**KIRKLEES METROPOLITAN COUNCIL
INVESTMENT & REGENERATION SERVICE**

DELEGATED DECISION TO DETERMINE PLANNING APPLICATIONS

Reference No:	2023/62/93293/W
Site Address:	8, Cockley Meadows, Kirkheaton, Huddersfield, HD5 0LA
Description:	Demolition of existing conservatory and erection of single storey rear and side extensions and formation of undercroft garage with associated engineering works to form access from Cockley Meadows
Recommending Officer:	Laura Yeadon

Officer Report

Drawing Title_
AS PROPOSED_ FLOOR PLANS

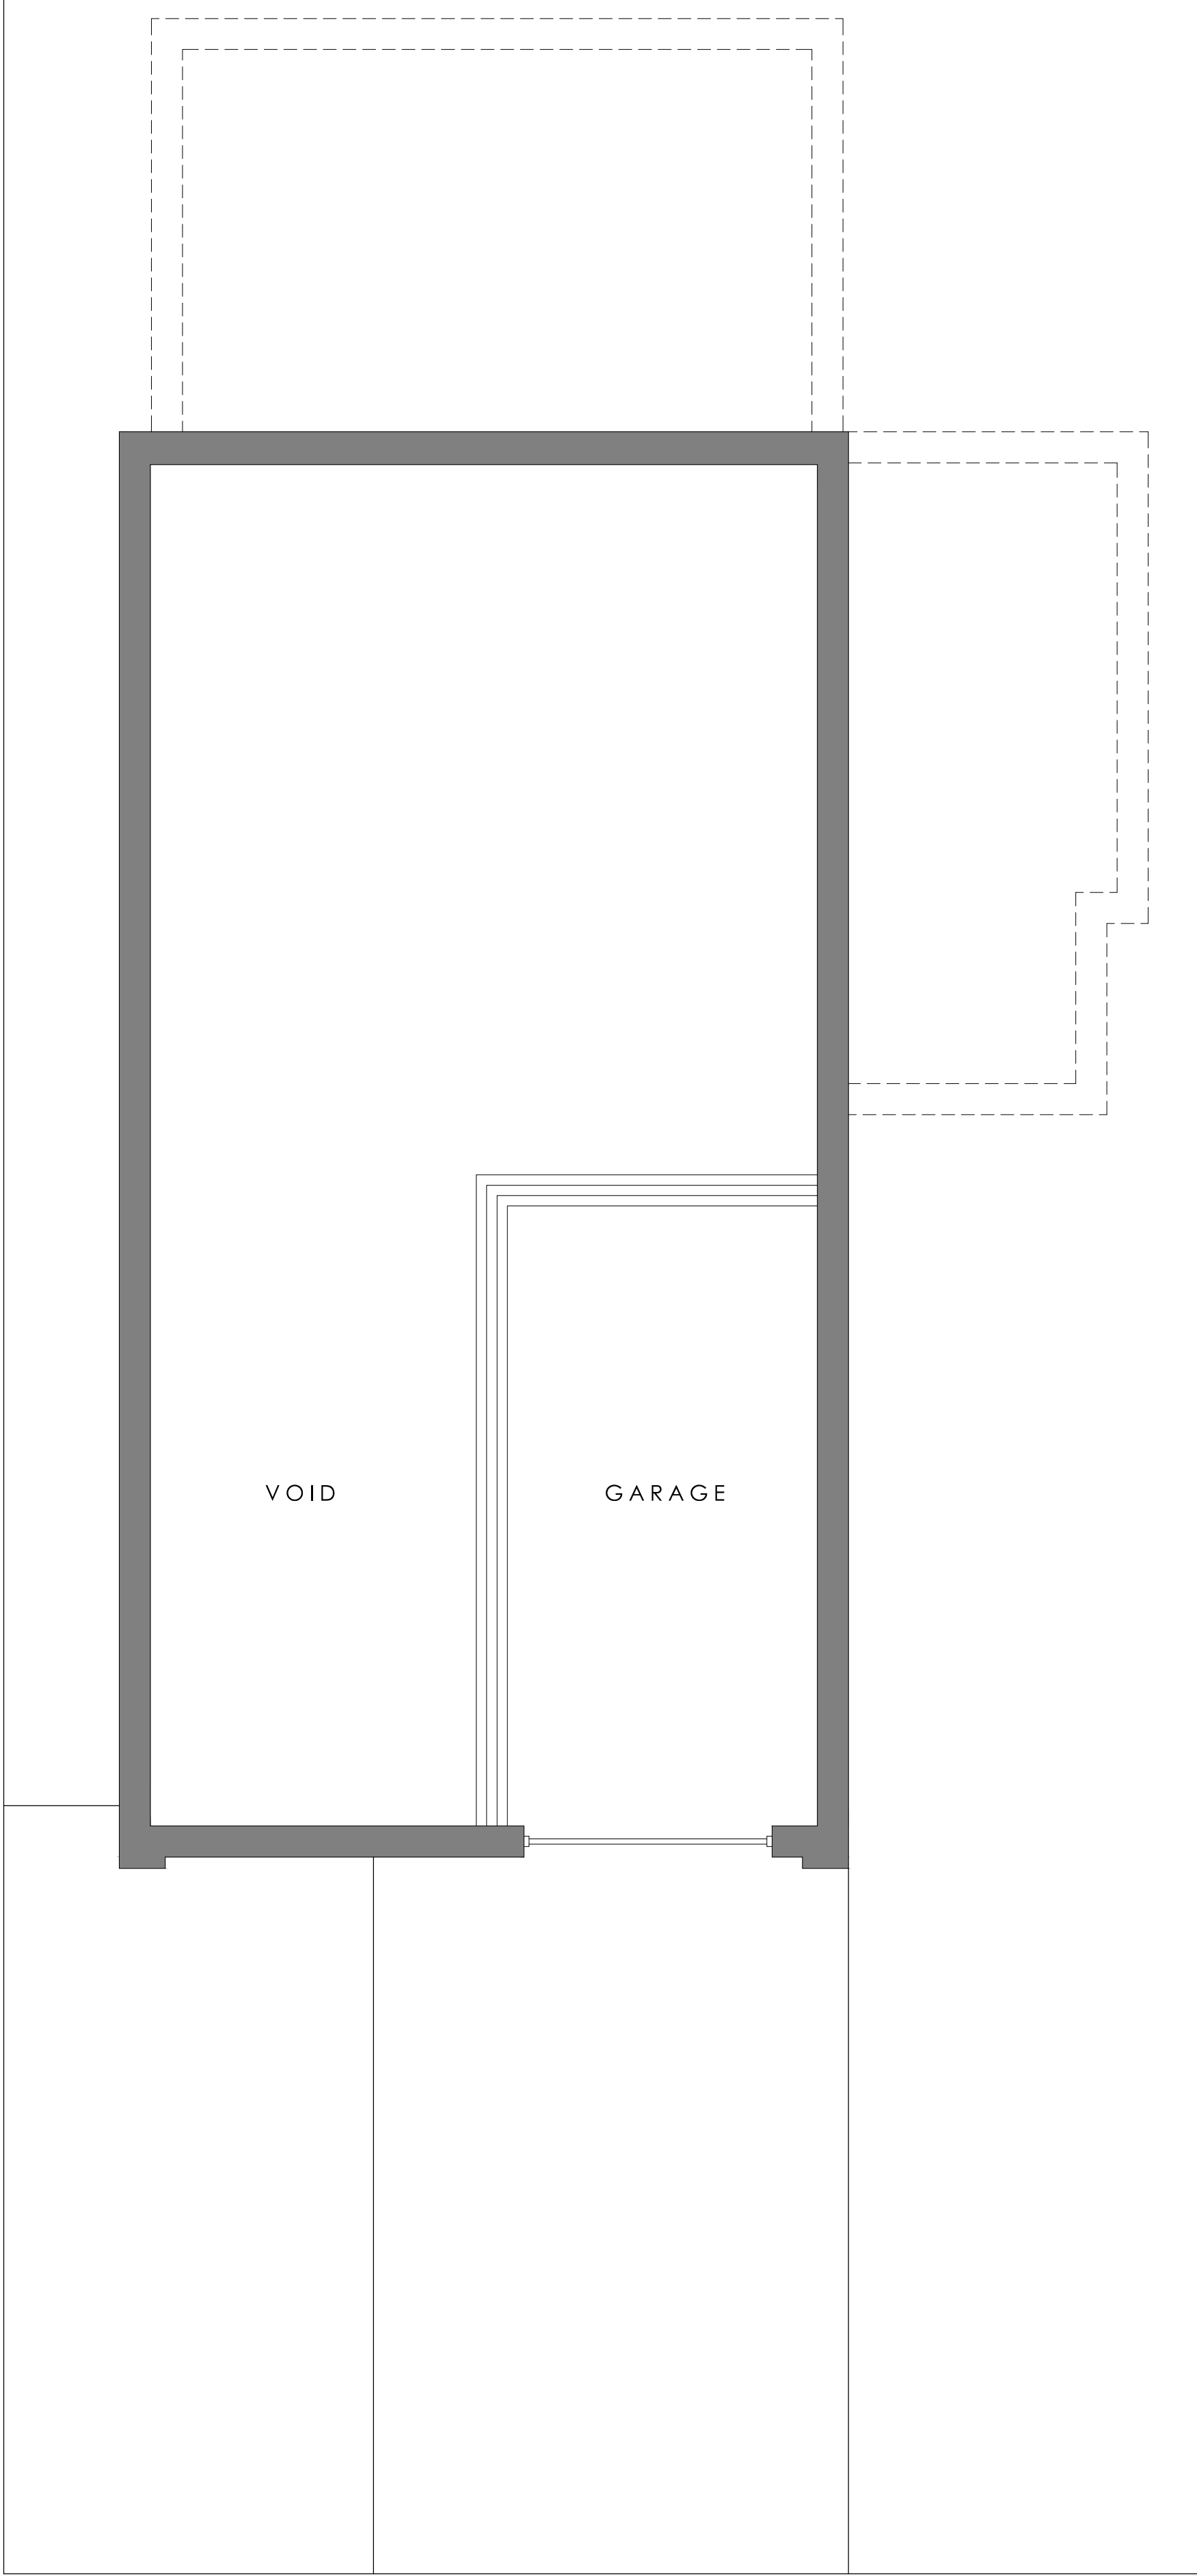
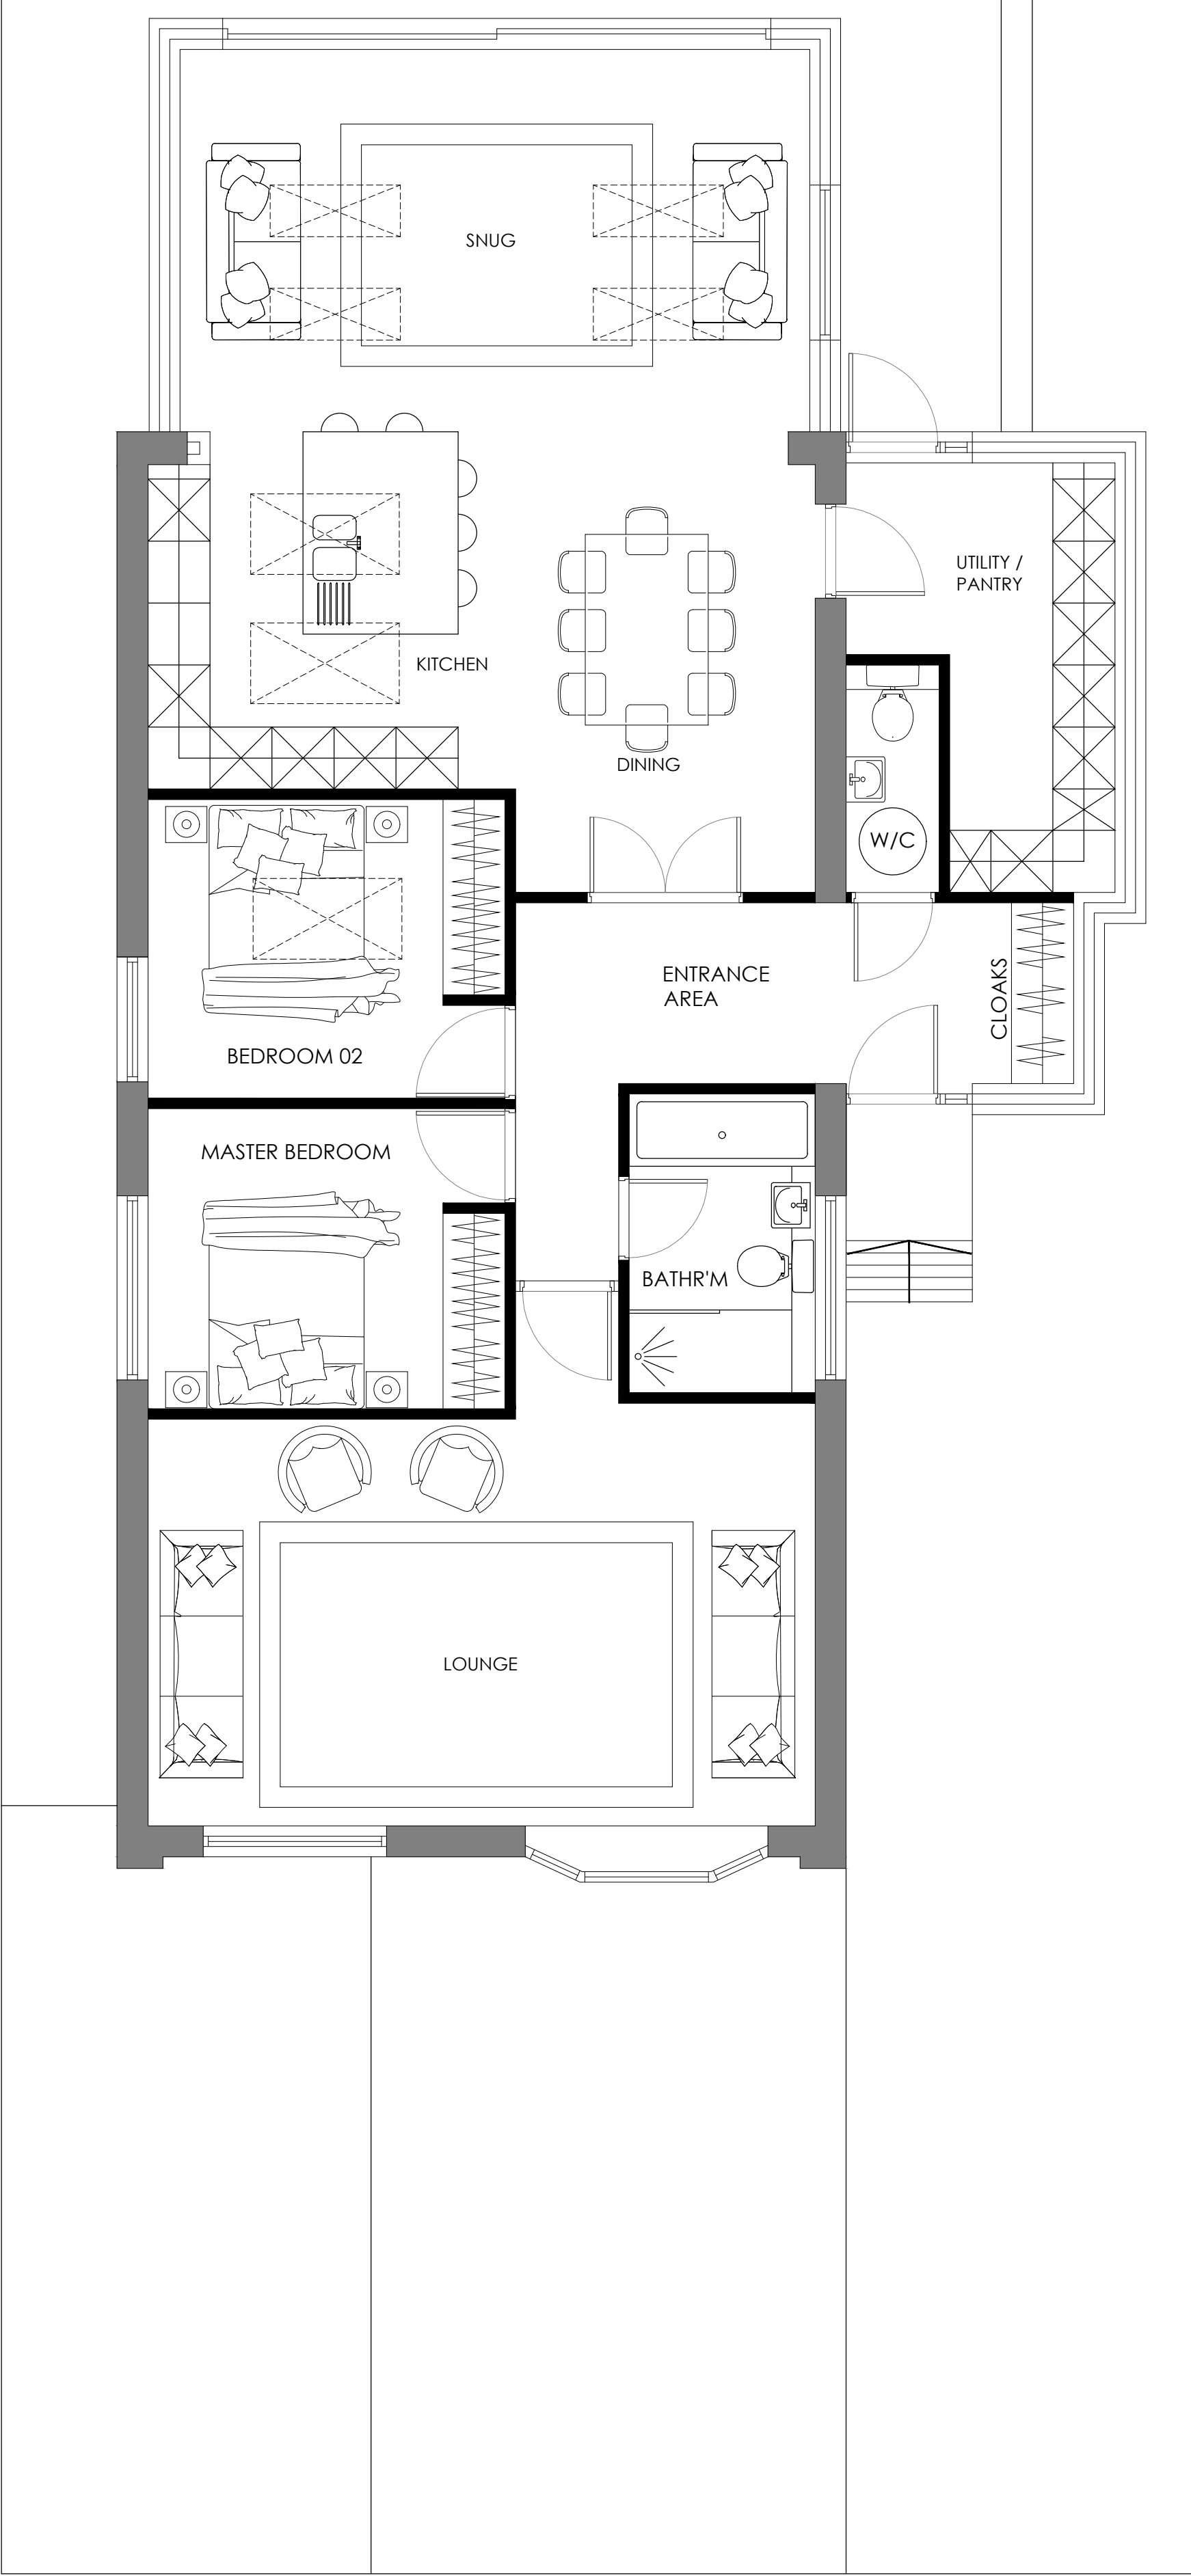
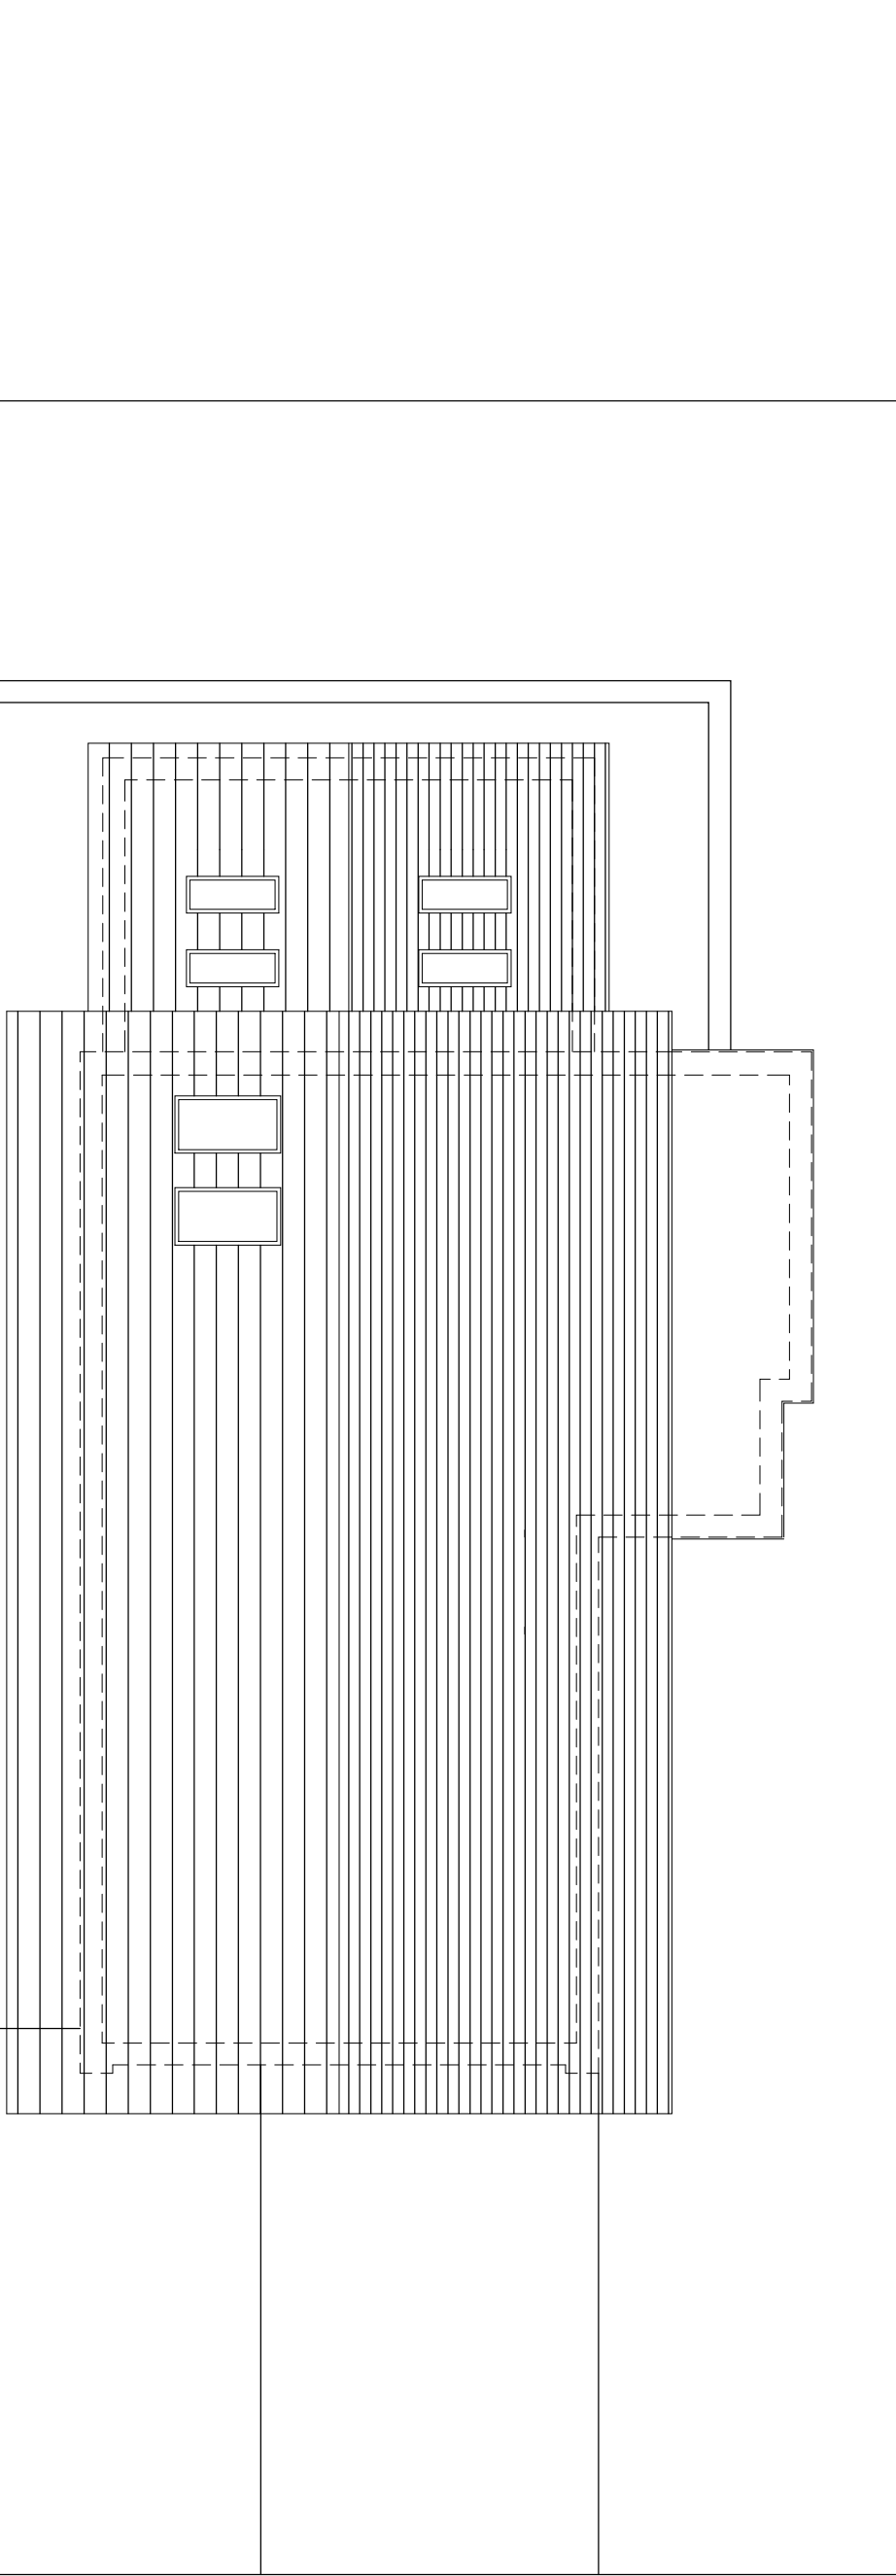
In this case the rear extension would be set in from the shared boundary with No. 10 by 1.4 metres therefore retaining a gap between the boundaries. This property (No. 10) is set back and in a slightly elevated position from the application site and therefore the projection of the rear extension would not extend beyond the rear elevation of this neighbouring property, as shown on drawing number 105 – Rev: C. There are no proposed openings facing this property and therefore minimal concerns regarding overlooking. In terms of overshadowing and/or being overbearing, given that the properties are detached with the proposed structure being single storey in height, it is not anticipated that there would be undue harm to this neighbouring property.

The proposed garage space has adequate dimensions in terms of the current guidance of internal garage space and the existing driveway would be retained which can accommodate a further vehicle to serve the two bedroom dwelling. In terms of the finish of the ground where the garage would be accessed, this would need to be finished with a porous surface to prevent surface water drainage issues and this can be secured via an appropriate condition.

SITE PLAN_ AS PROPOSED

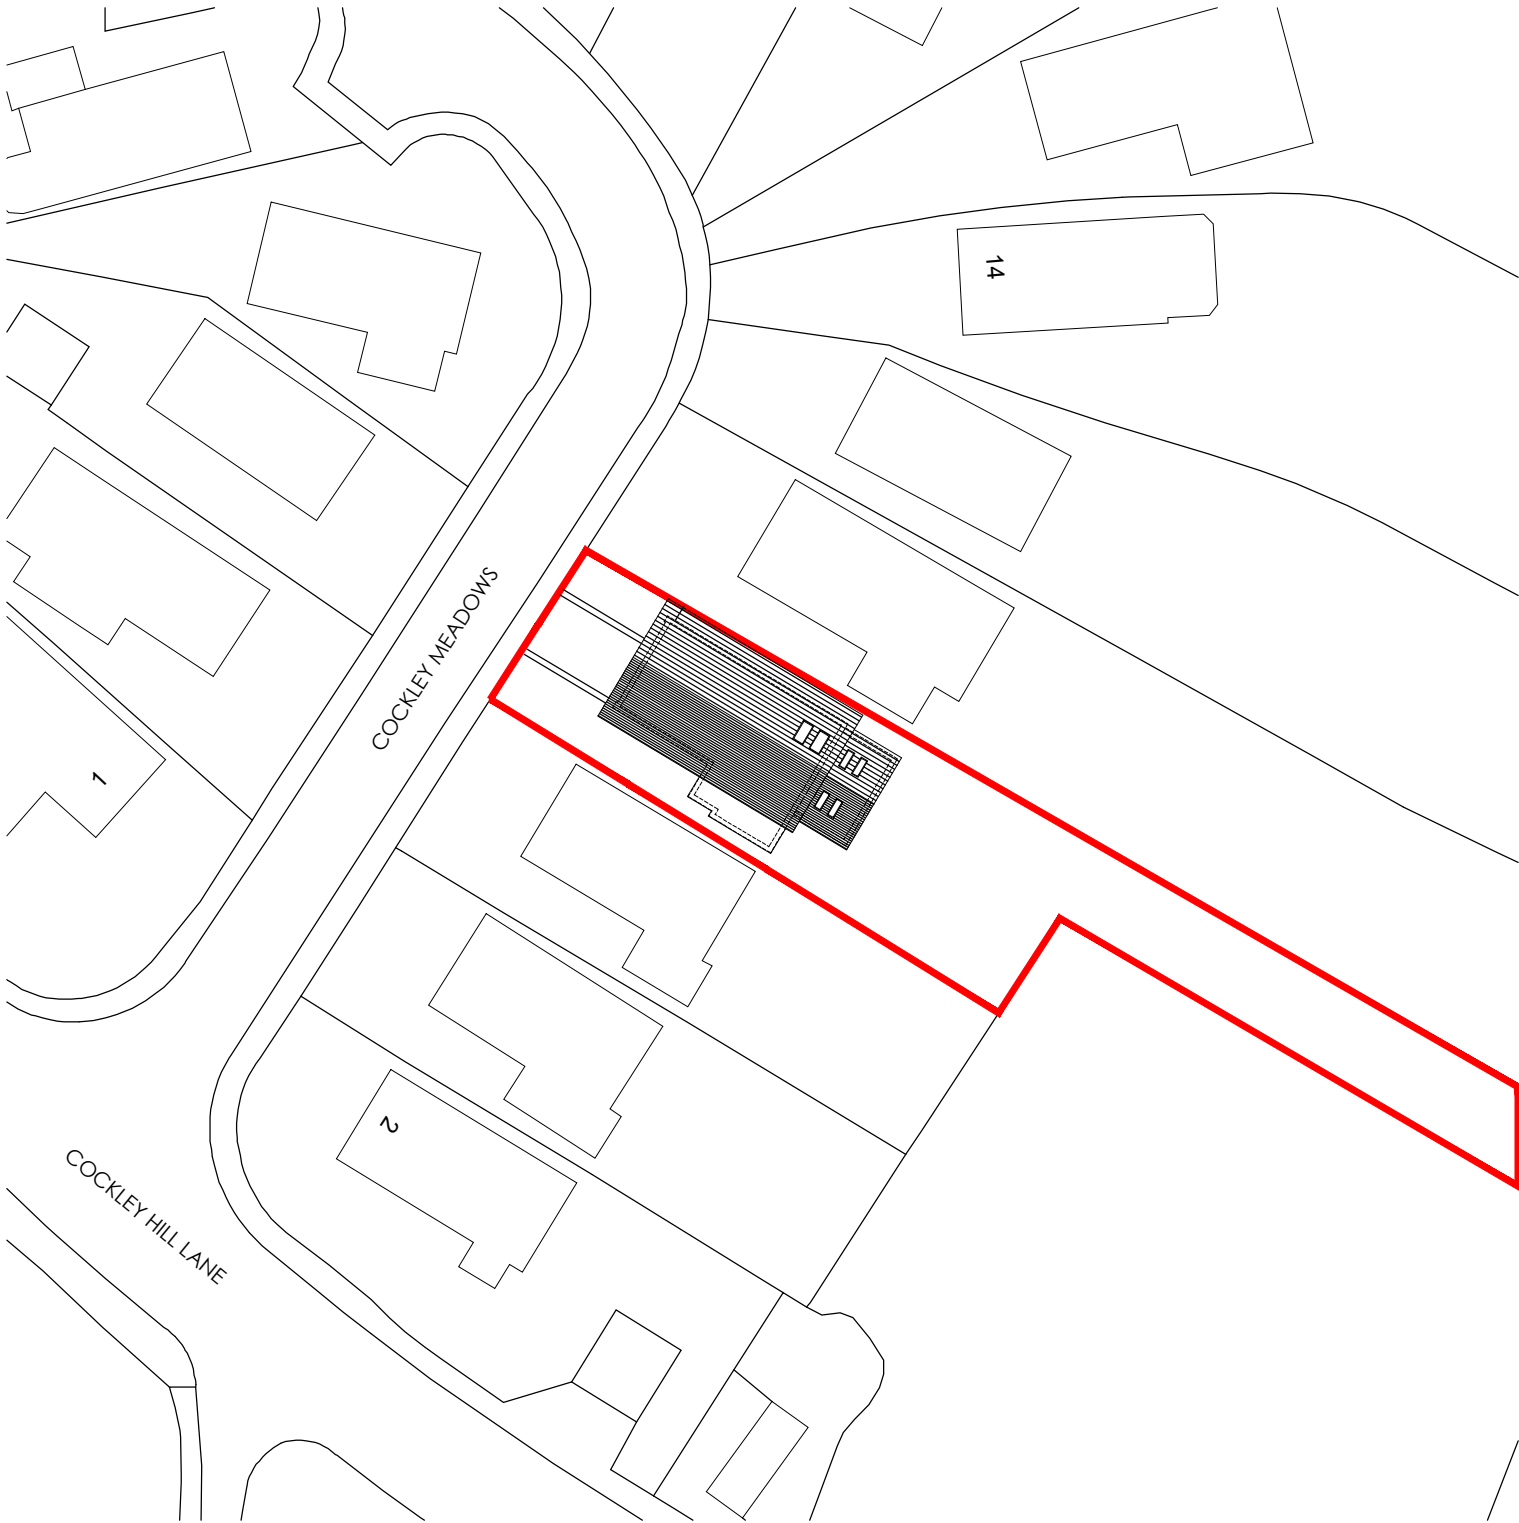
In this case, concerns were raised with the Agent in relation to the retention of retaining walls and the impact on pedestrian safety due to the potential lack of visibility when exiting the garage. In response, the Agent has updated the proposed site plan to demonstrate that visibility splays of 2.4m x 70m can be achieved.

However, additional plans have been requested to demonstrate visibility splays from the proposed driveway in terms of highway safety. The updated plan was submitted on 22nd January 2024 under plan number 105, revision C.
